Final Report - Corrections Required **Application No. ANEX-24-0007**

Description : Matrix Design Group on behalf of Colorado Springs Equities LLC is submitting a serial annexation petition for seven parcels and Land Use Plan/Rezoning exhibit for a portion of the subdivision known as Rock Creek Mesa.

Document Filename : Rock Creek Mesa Addition No 6_Annexation Plat_V3_5-13-24

ANNEXATION PLAT

ANNEXATION PLAT

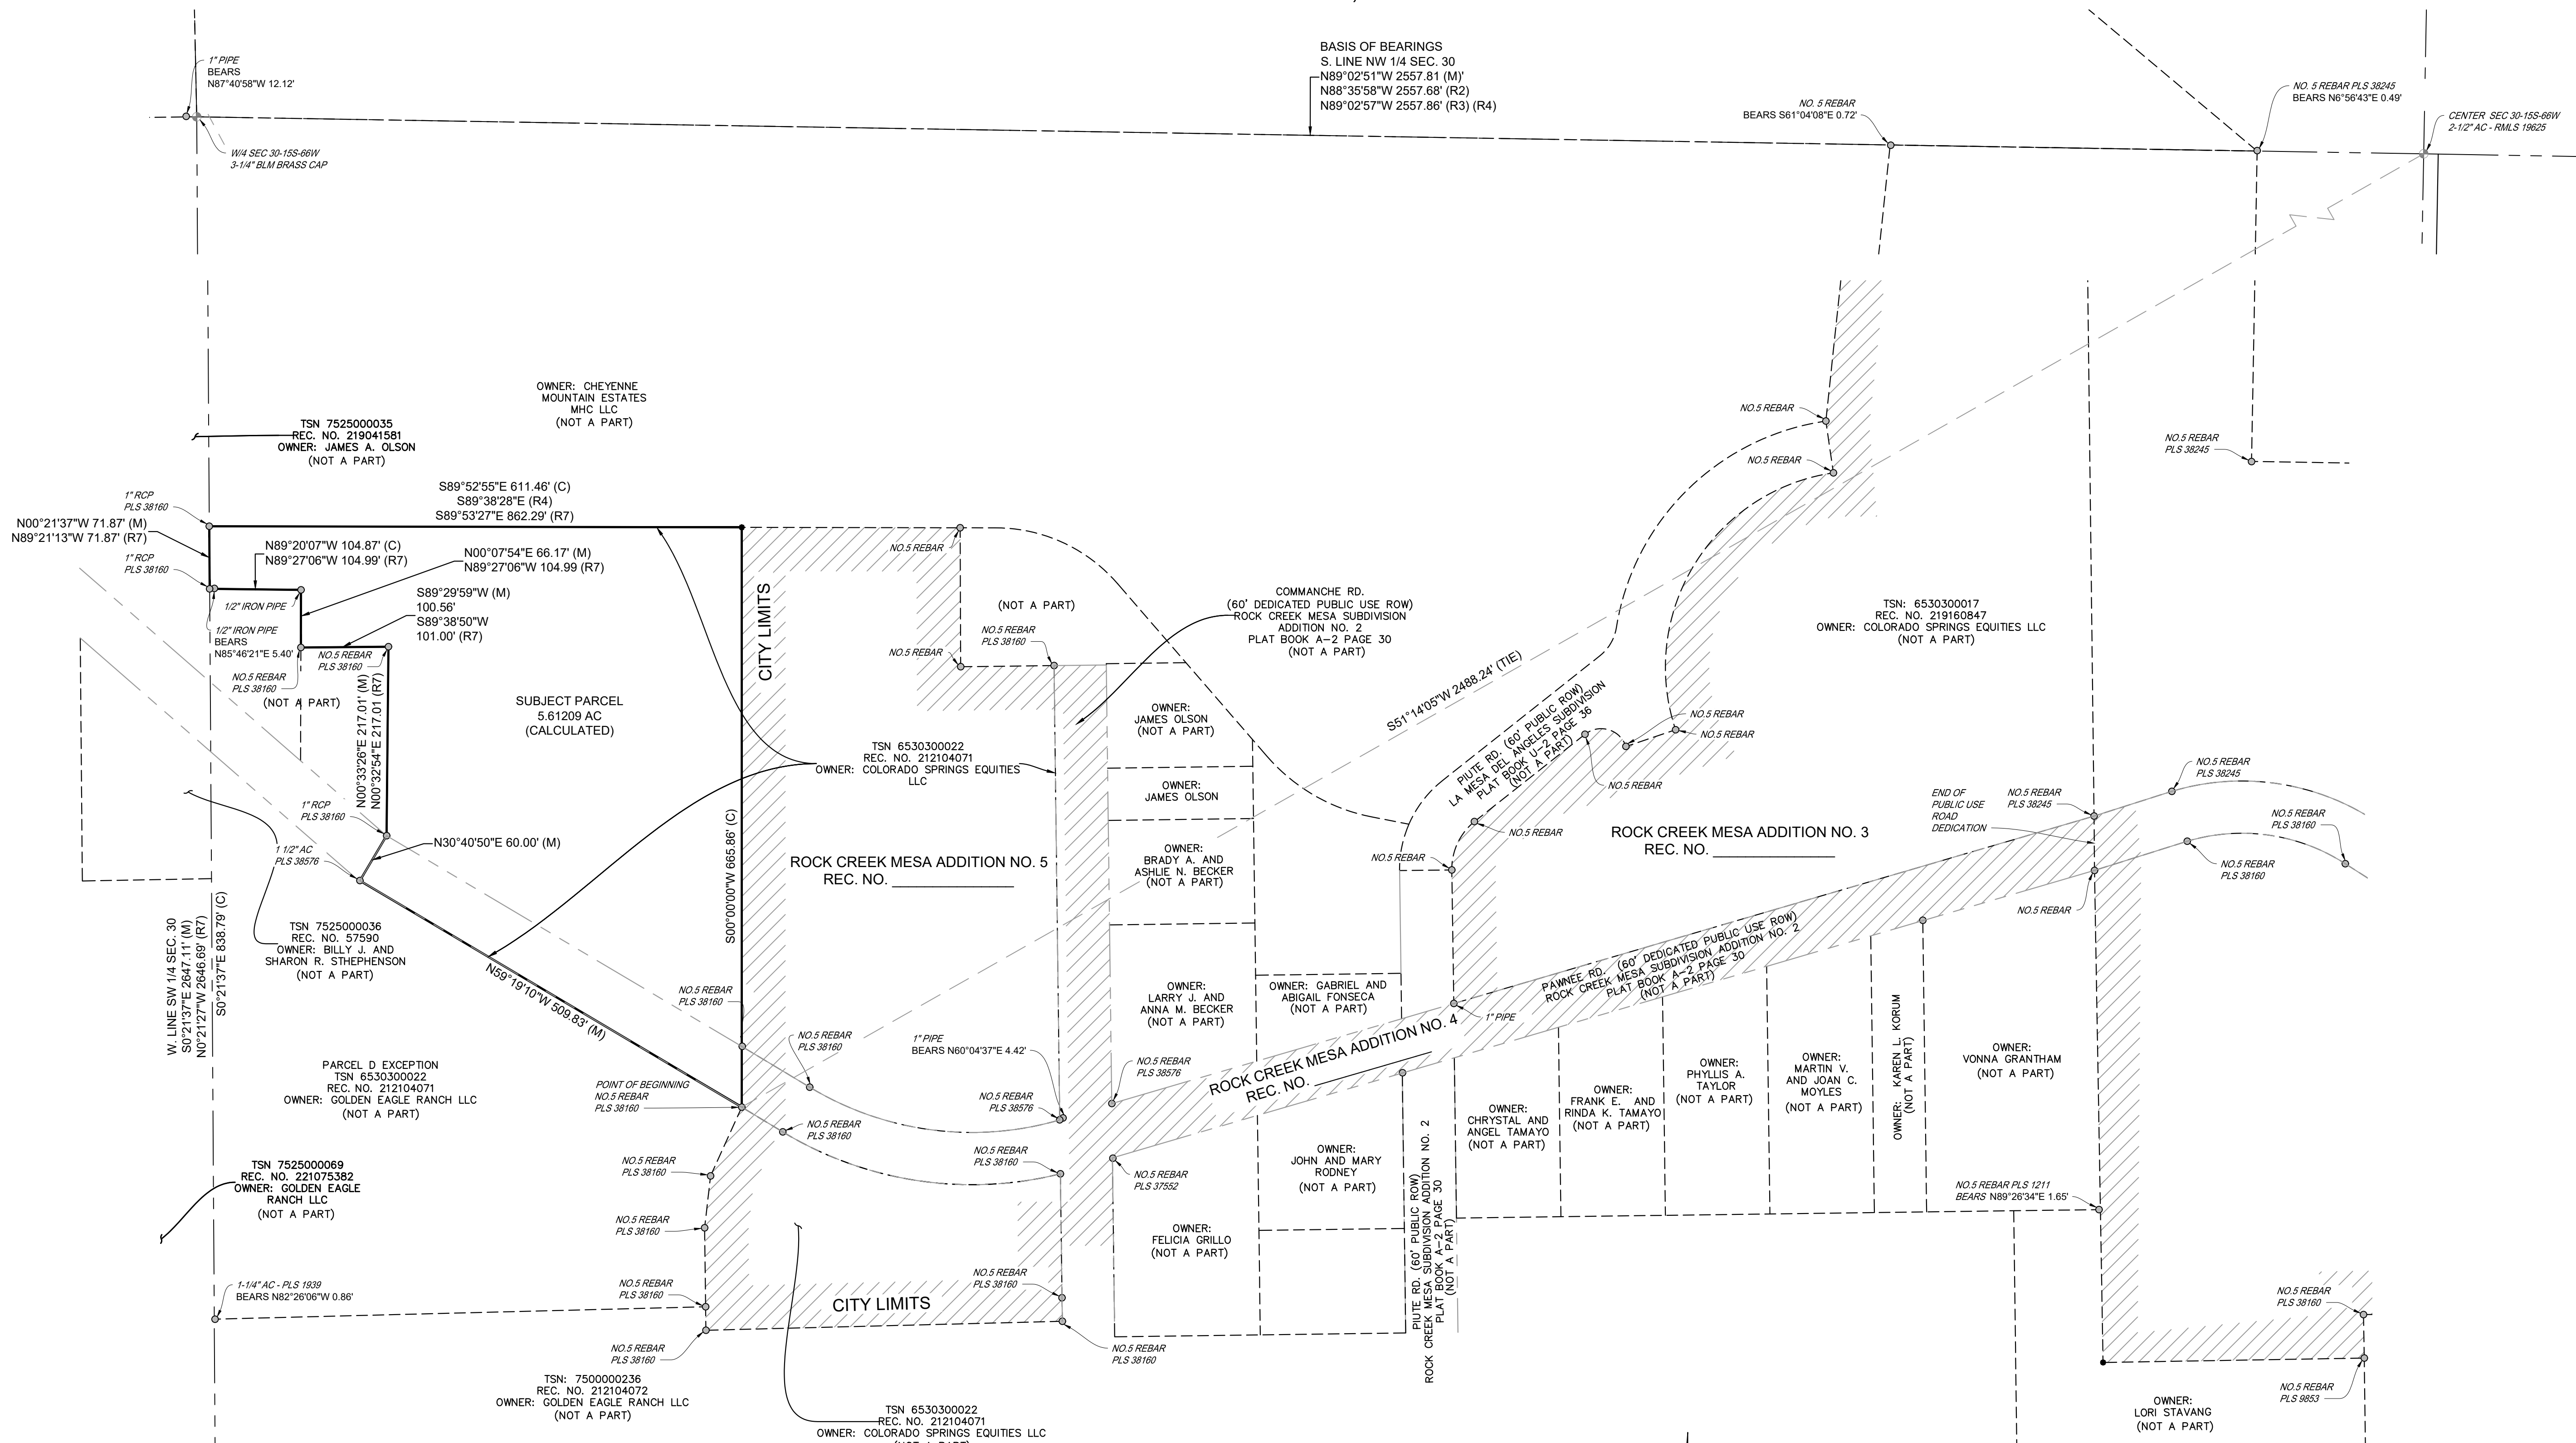
Comment ID	Page Reference	Reviewer : Department	Review Comments
33	1	Caelen Wendt : Col Springs Utilities	Please be more specific about where the point of beginning is.
35	1	Matthew Alcuran : Col Springs Utilities	Please address LBS comment.
43	1	Cory Sharp : Planning	please note that this number is from the closure sheet, if you add up each line separately (how others would calculate) you come up with 2407.63' (that happens on several additions, please check/revise accordingly
44	1	Cory Sharp : Planning	please determine the name and title of the person signing and complete under owner and notary (so we are not waiting till the end and it be overlooked)

-	2	Cory Sharp : Planning	
-	2	Cory Sharp : Planning	
-	2	Cory Sharp : Planning	
36	2	Cory Sharp : Planning	Please check/revise there is over 40' of difference
37	2	Cory Sharp : Planning	per exhibit B of the zone change (zone-23-0030) the right-of-way is not parallel and the south side has two different bearings
38	2	Cory Sharp : Planning	Where does the platted right-of-way stop, please depict and label
39	2	Cory Sharp : Planning	please depict and label this section of right-of-way with ownership and record information
41	2	Cory Sharp : Planning	please consider adding point of commencing to the center of section and adding the tie to the legal description. (Please add that information on all the additions that are showing said information, the comment was not added to the previous additions, please add accordingly to all that it applies to)
42	2	Cory Sharp : Planning	please be more specific on the description of the point of beginning

Please address LBS comment.

please note that this number is from the closure sheet, if you add up each line separately (how others would calculate) you come up with 2407.63' (that happens on several additions, please check/revise accordingly)
